**Land Approx 1 Mile From J9 East Of M40 Part Of
M40 Through Chesterton Parish Chesterton**

22/01599/DISC

Proposal: Discharge of Conditions 6 (colours and materials of any water slide, wolf, or other external built feature), 24 (footpath specification details) and 25 (Construction Traffic Management Plan) of 21/04158/F

1 OVERALL PLAN
NO SCALE

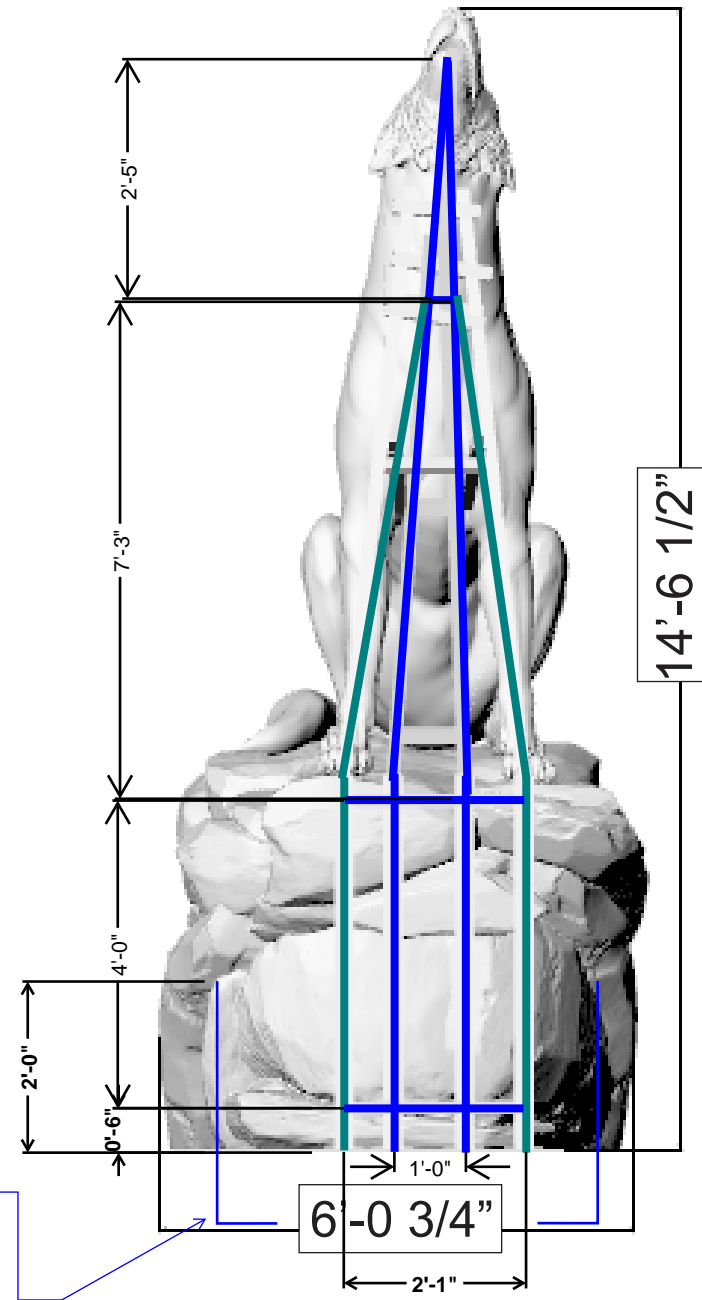
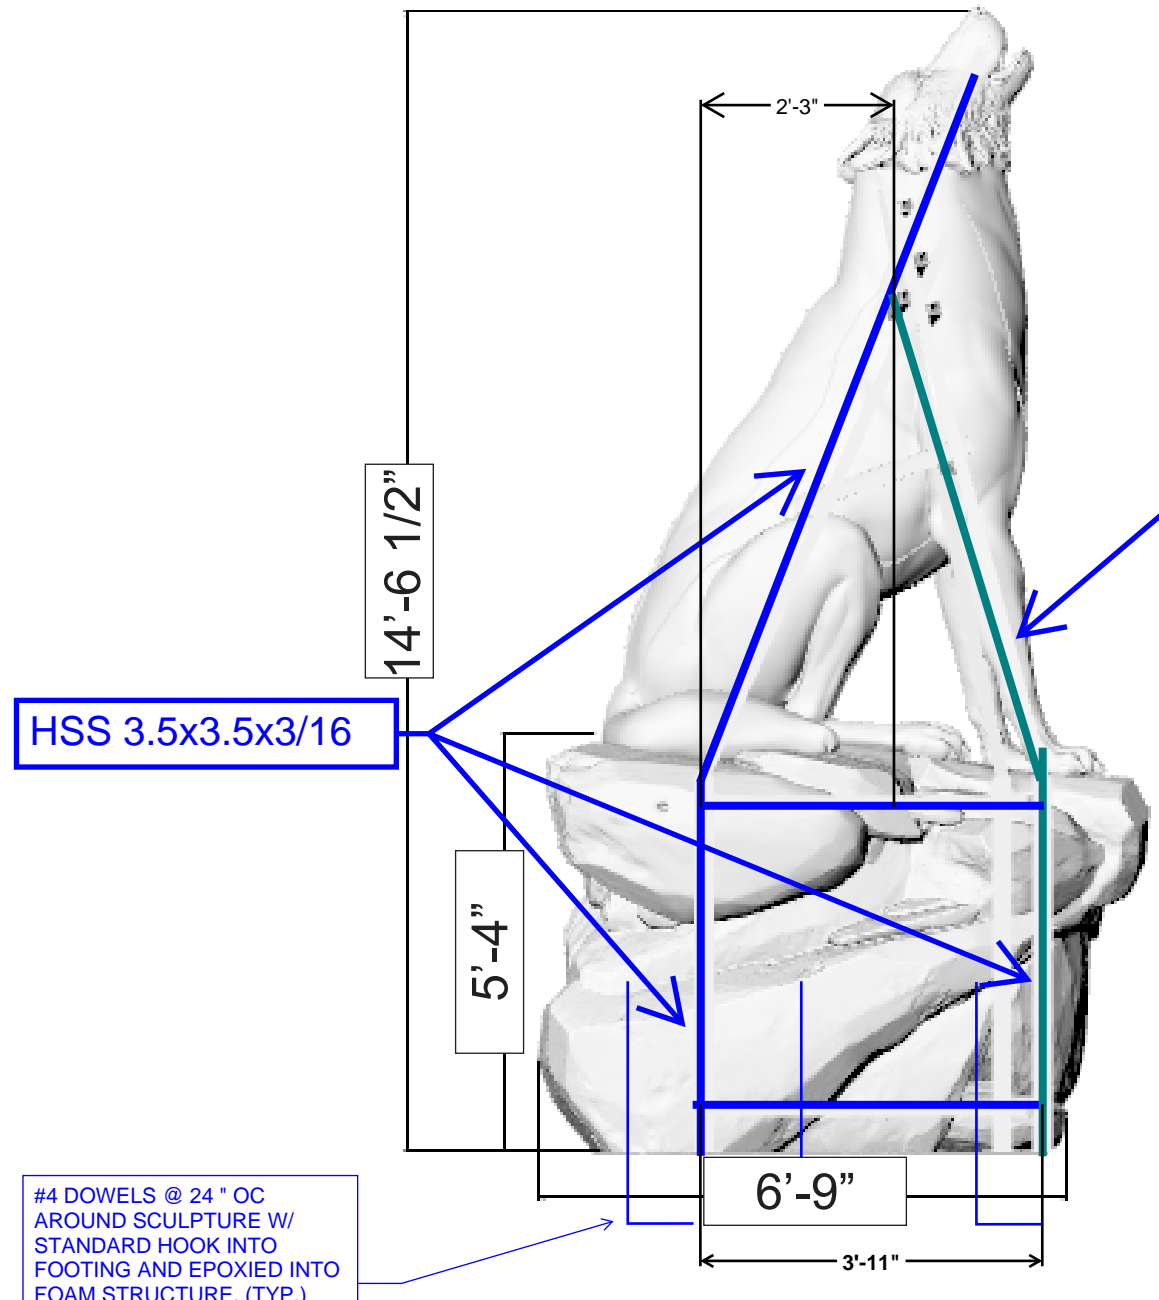
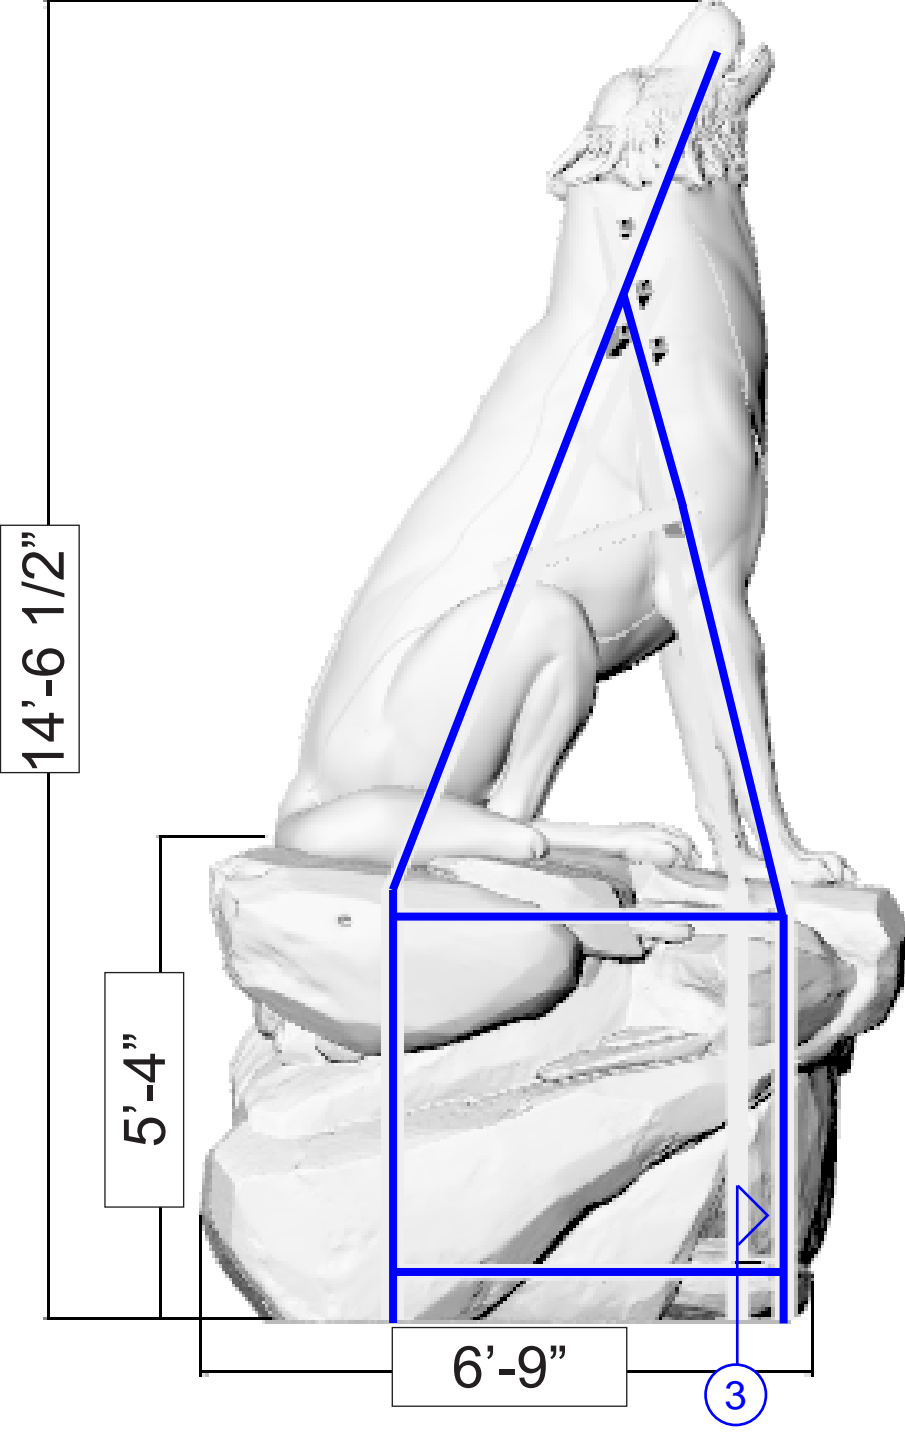
- 5.1. CDC Environmental Protection – Is satisfied that condition 25 can be discharged.
- 5.2. OCC Highways – Have no comment on Condition 6, No objection to Condition 24 and 25 following the receipt of the amended CTMP.
- 5.3. CDC Landscape - Have considered the proposals and my only comment is the wolf sculpture is not as finely carved as I would of hoped. I would suggest a local artist is employed to design and create an exemplary piece of sculpture.

- 6.2. The applicants have also provided details of the Wolf Structure, and although the design could be better, I do not consider the overall design is sufficient to warrant a refusal. In addition, the wolf is part of the overall branding of the developers. On the basis of this information, it is considered that the proposal is considered to be acceptable in order to discharge condition 6.

Wolf Sculpture Drawing Pack (19095934) and Flume Details 4540829 Rev A received 30 May 2022.
